From: Joney Ramirez <[REDACTED]>
Sent: 29 November 2019 12:46
To: [REDACTED]
Cc: Karl Roberts <[REDACTED]> Nick Laister <[REDACTED]> nic burrell <[REDACTED]>
Subject: A/100/19/PL - Arundel Acre - response to Highways England
Importance: High

A response has been received from Highways England requiring more information on the proposal for Arundel Acre, Angmering (application ref. A/100/19/PL) and we would like to address this request as follows.

1711056-SK01

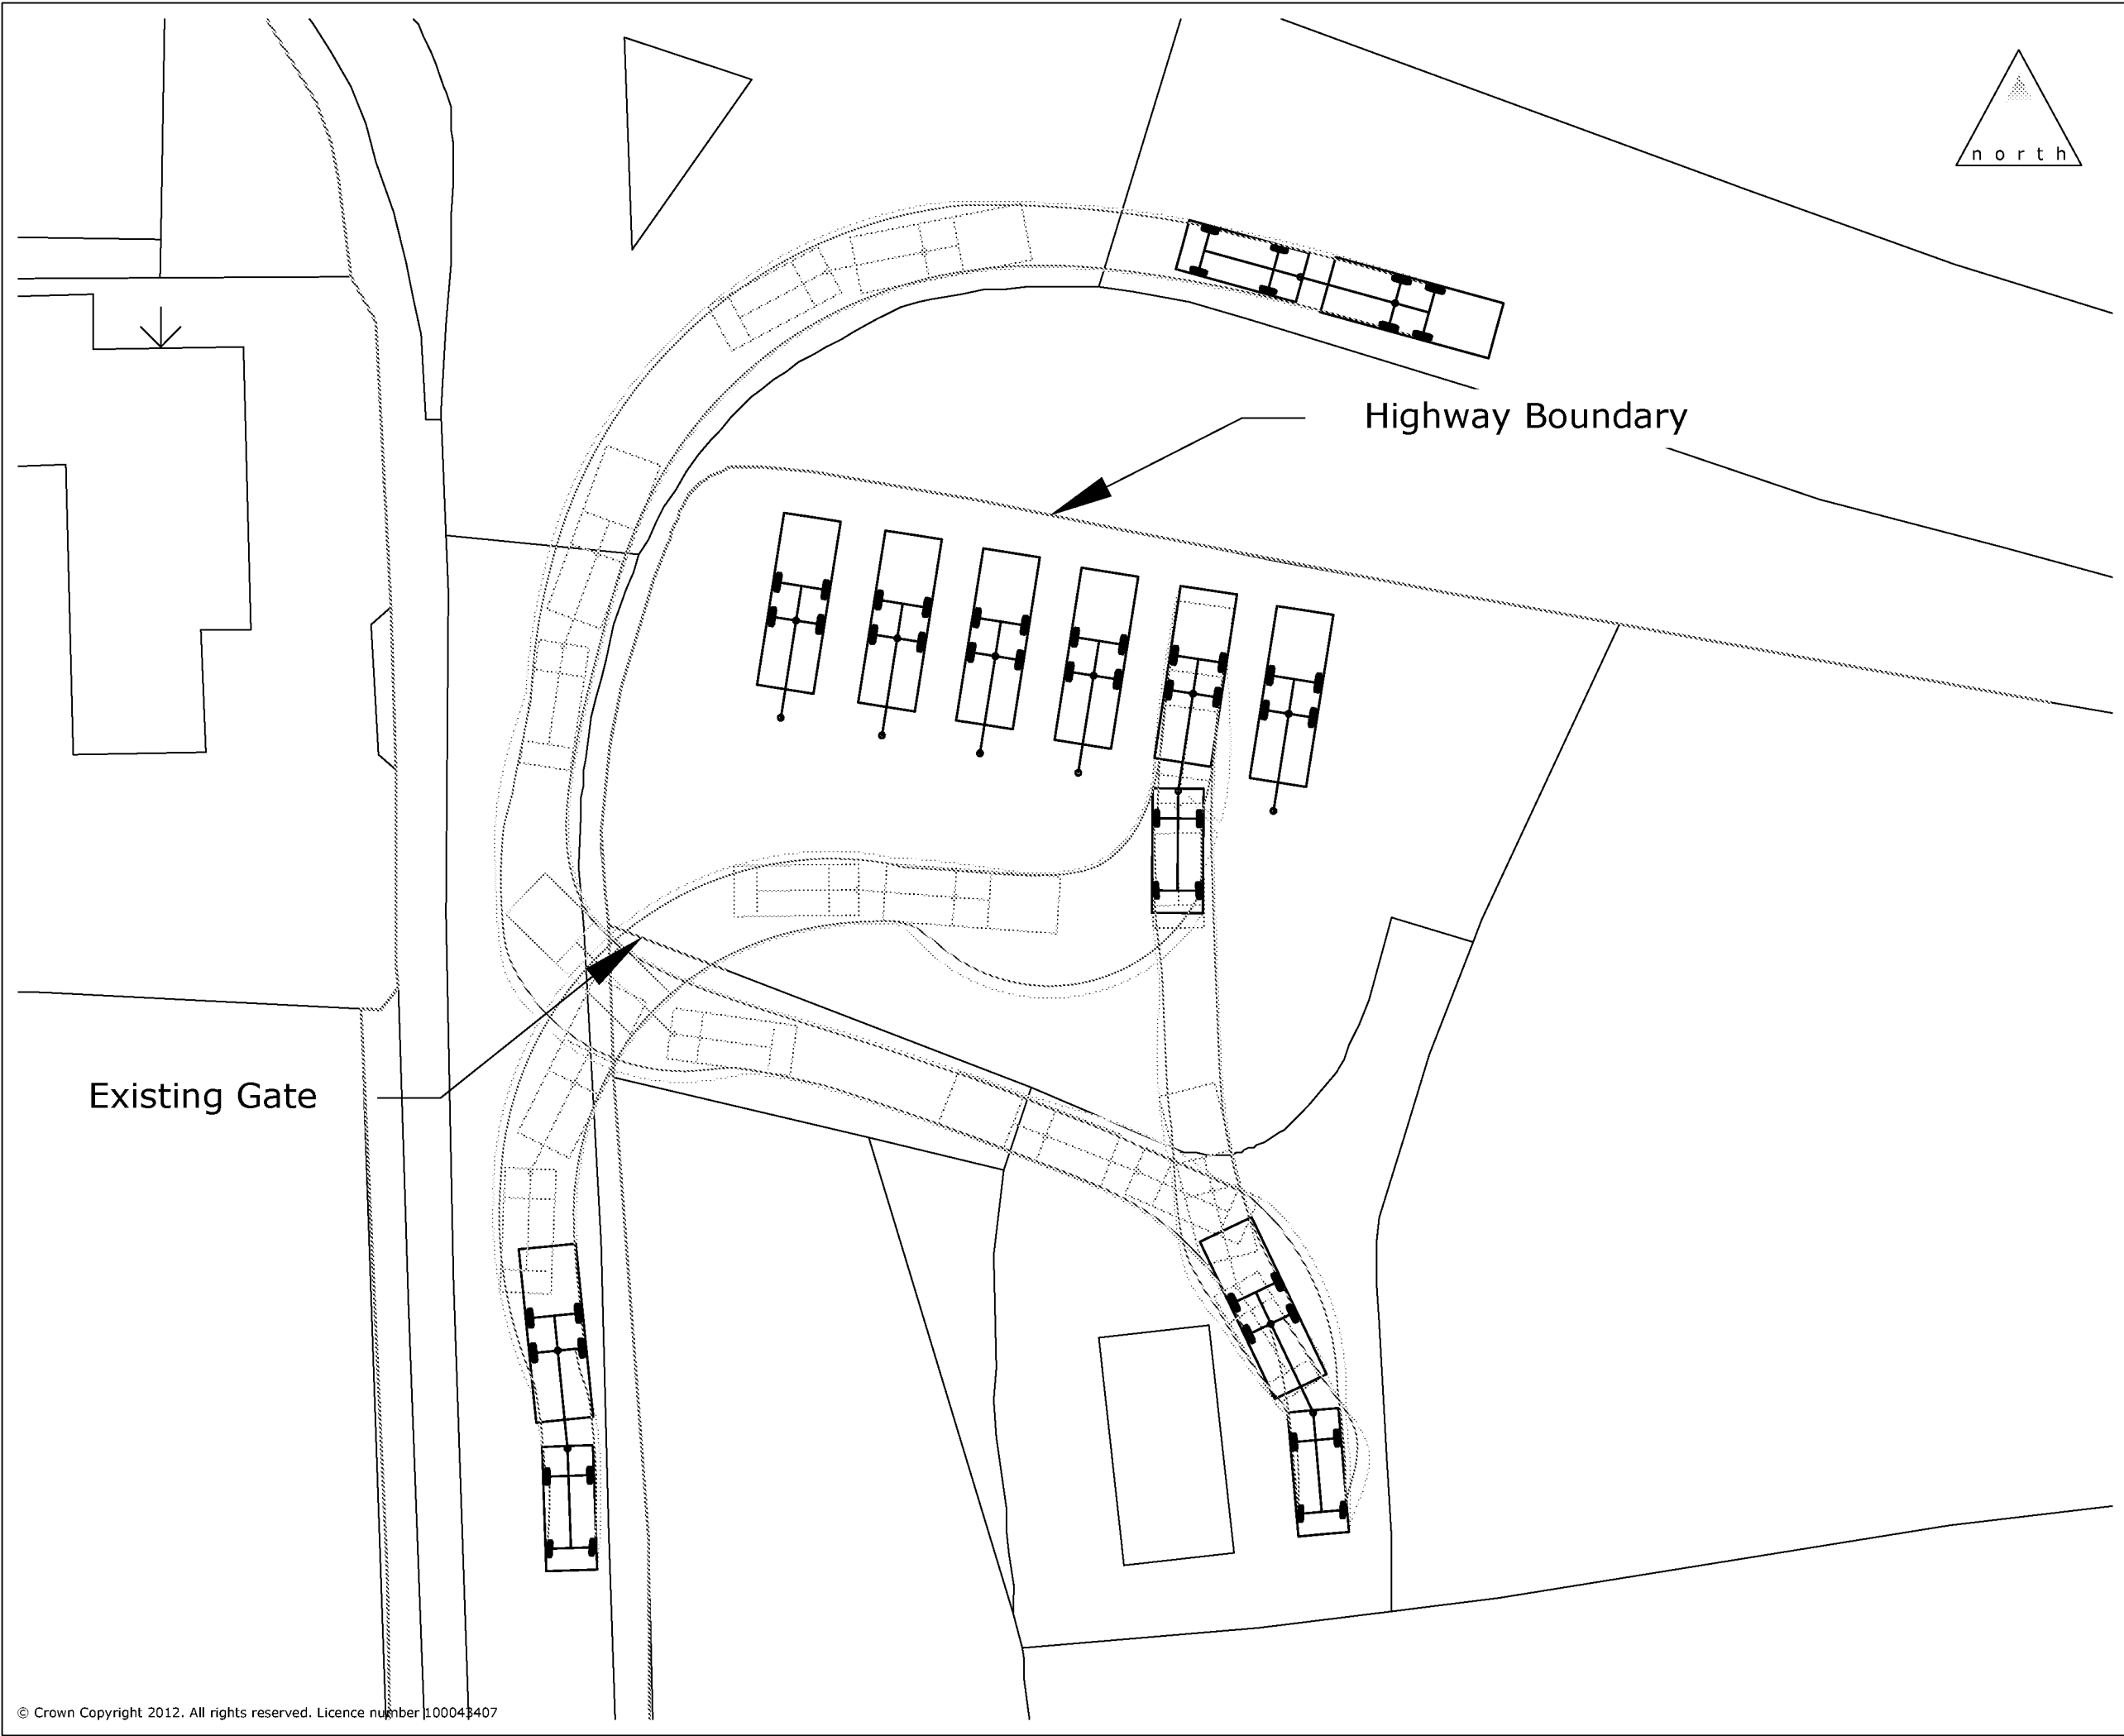
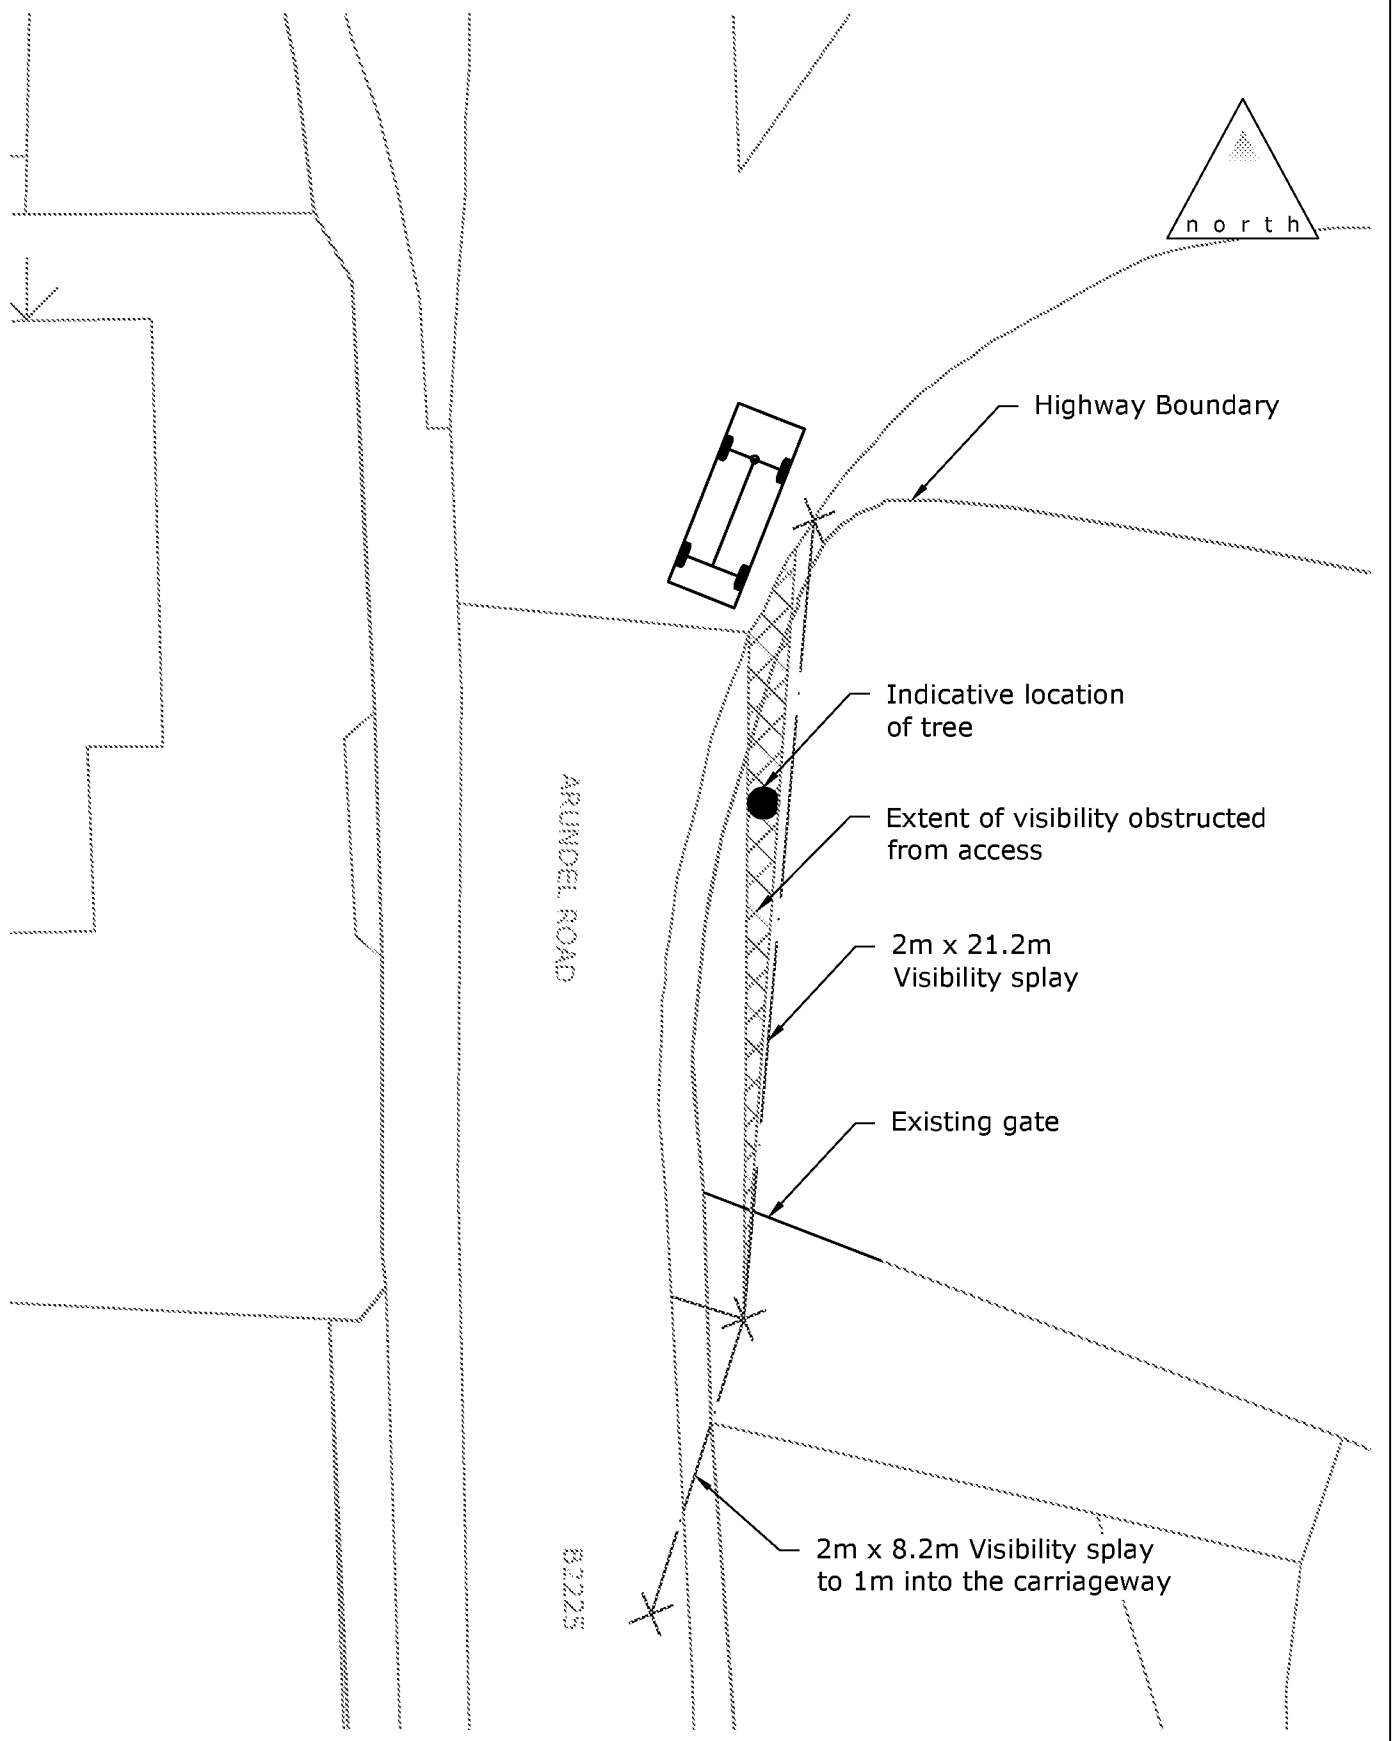
You have requested that the visibility splay be based on DMRB and not on MfS – You will note that, as during the assessment of the planning application, the planning Inspectorate accepted on Paragraph 8 of the Appeal Decision that the northern visibility splay, shown on **Appendix D** - Drawing SK01A achieving 21.2m **“now meets the requisite standard set out in Manual for Streets (MfS)”**. Such approach is consistent with the lack of objection received from Highways England for the previous proposal and therefore we consider it is unreasonable to request this visibility splay now to be based on DMRB.

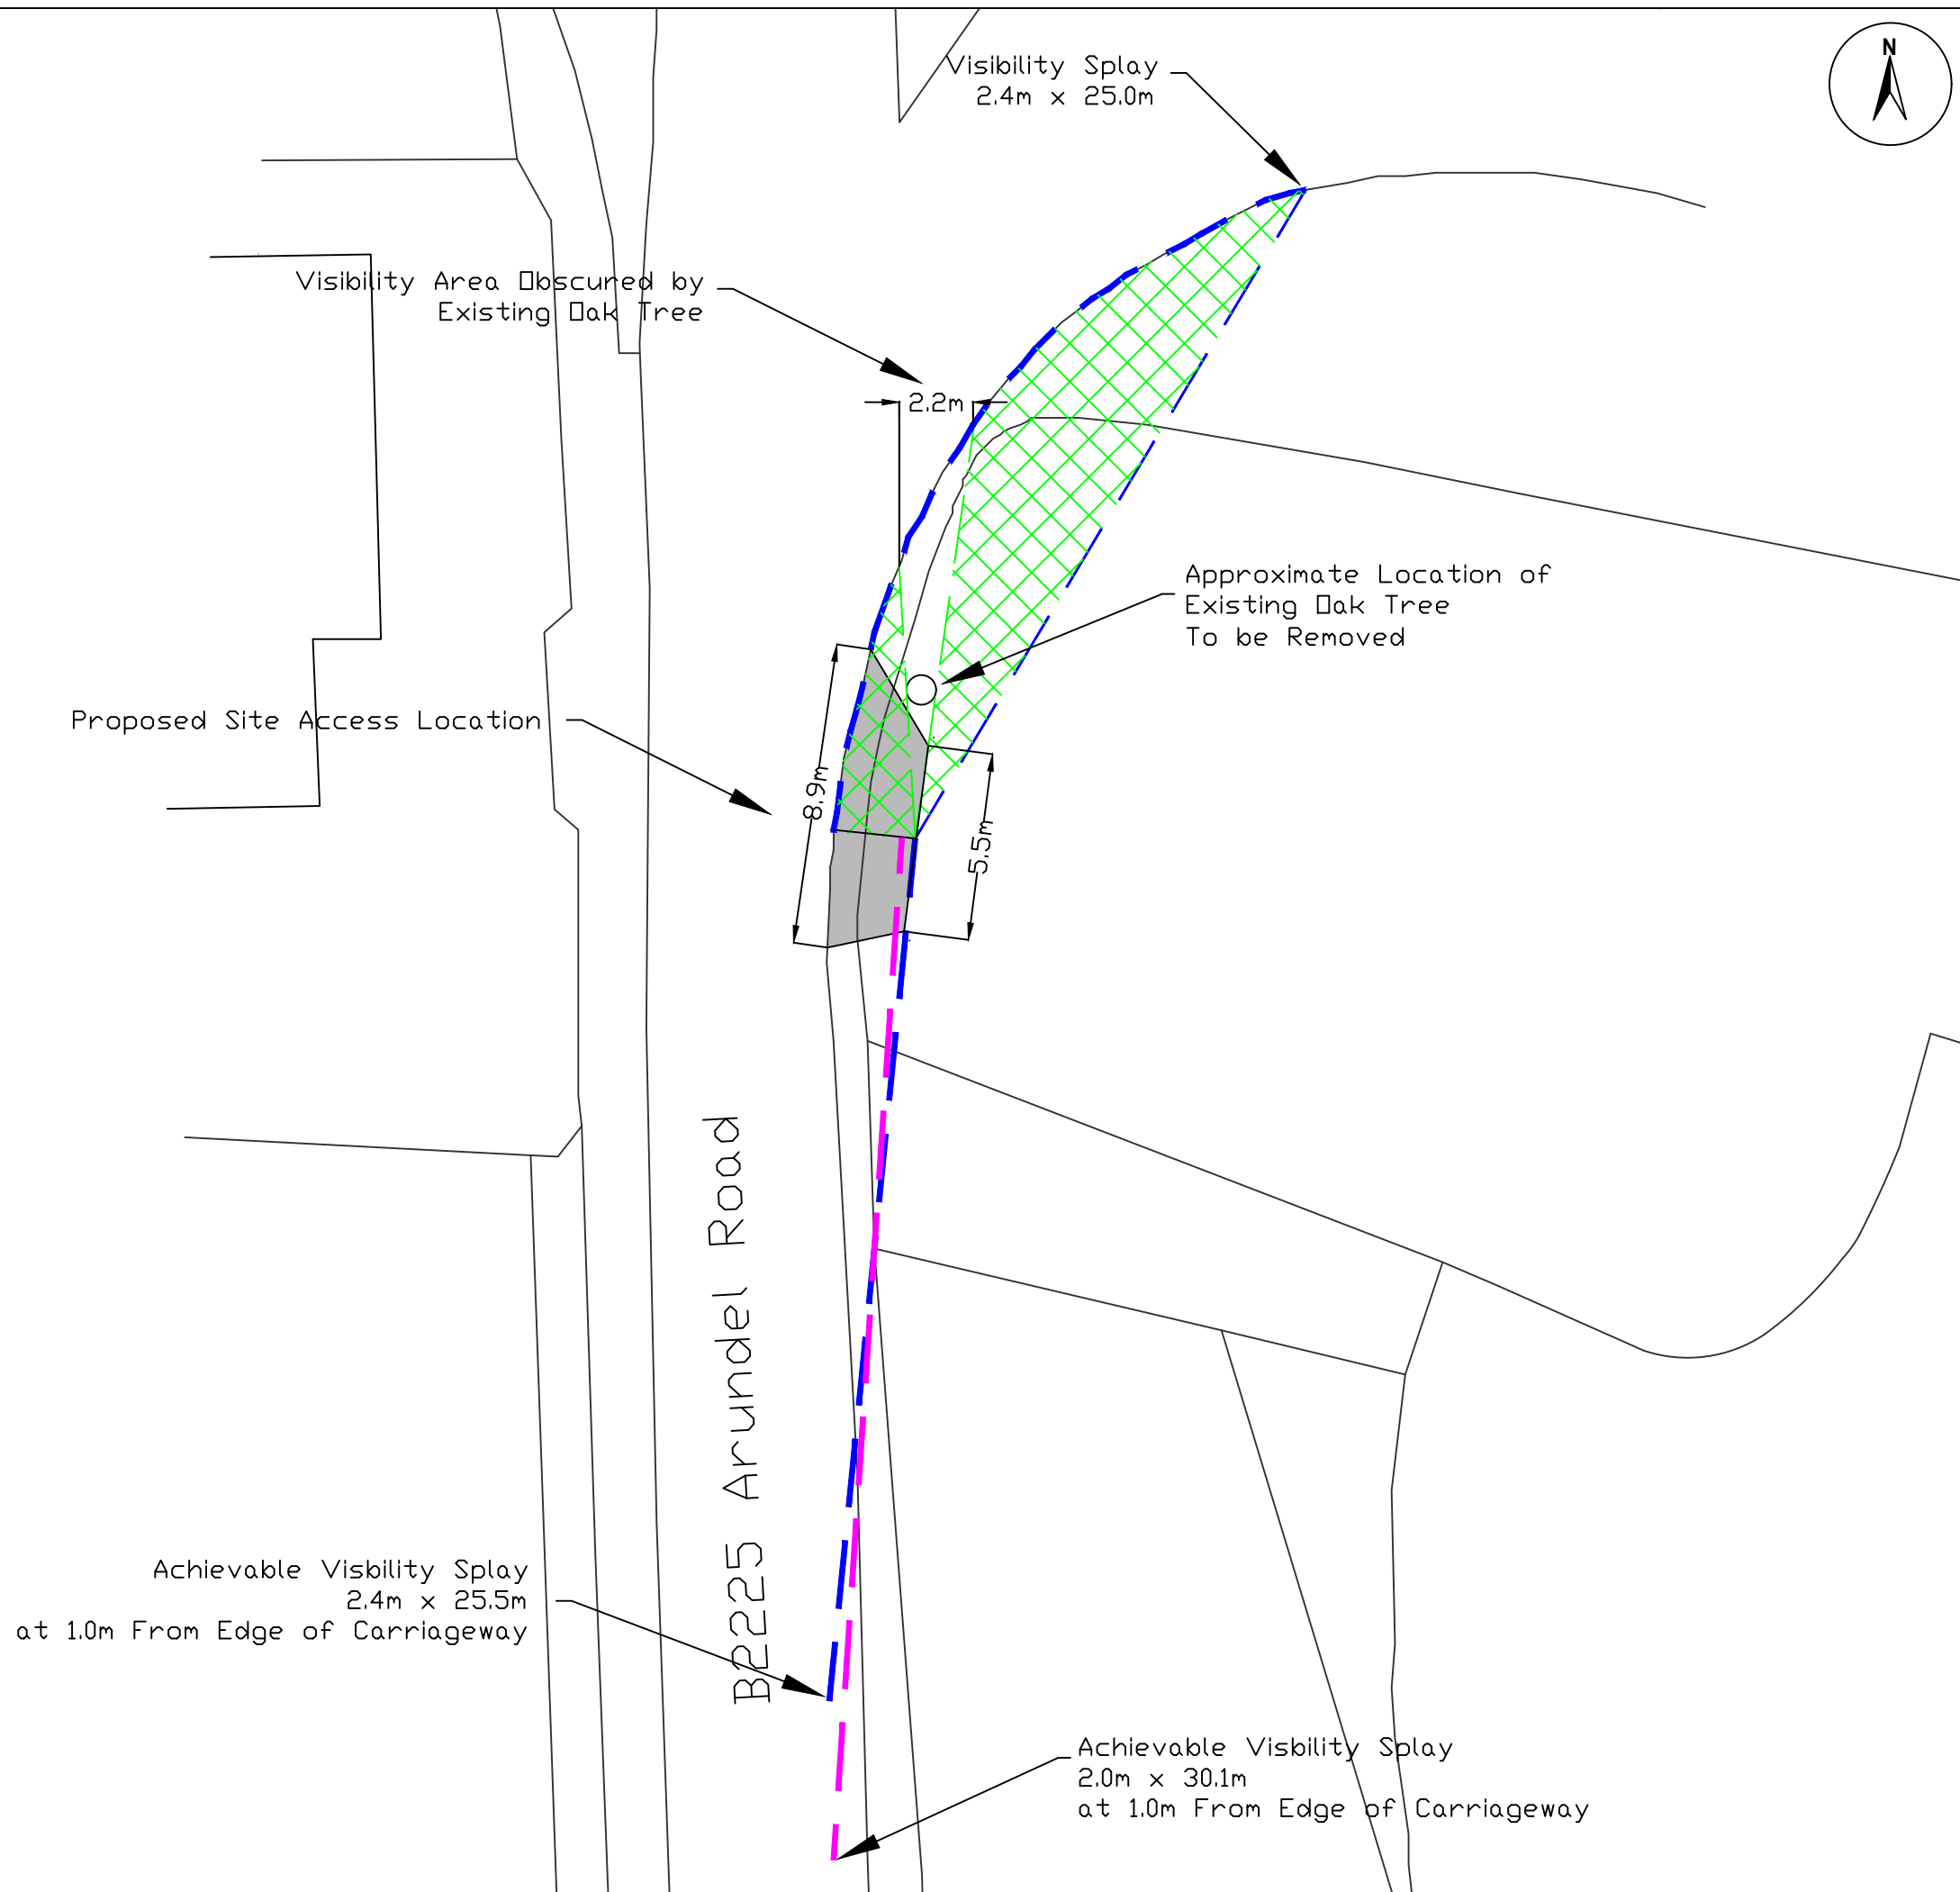
In addition, we would like to highlight that we are proposing the access road to take place off Arundel Road and not the A27. Arundel Road is not a trunk road and therefore the visibility splays have been calculated based on MfS and not DMRB. We consider this approach to be consistent with previous assessments on the site and take into consideration MfS2 guidance which states that the strict application of DMRB to non-trunk routes is rarely appropriate in built up areas, regardless of traffic volume and that, even where DMRB is used, designers should bear in mind the key principles of MfS and apply DMRB in a way that respects local context (paragraph 1.3.3).

We hope this clarifies the proposal and its implications and that you reconsider the north visibility splay to be based on MfS and not on DMRB.

We are of the view this information will assist Highways England to address the concerns regarding speeds and visibility at the site. We would also like to highlight that attached Drawing No. JNY10317/01a shows the proposed north visibility splay to be 25m and takes into consideration that the applicant has reduced the original hedges to significantly improve visibility, for the overall benefit of highway safety. Such visibility splay is considered to comply with MfS requirements.
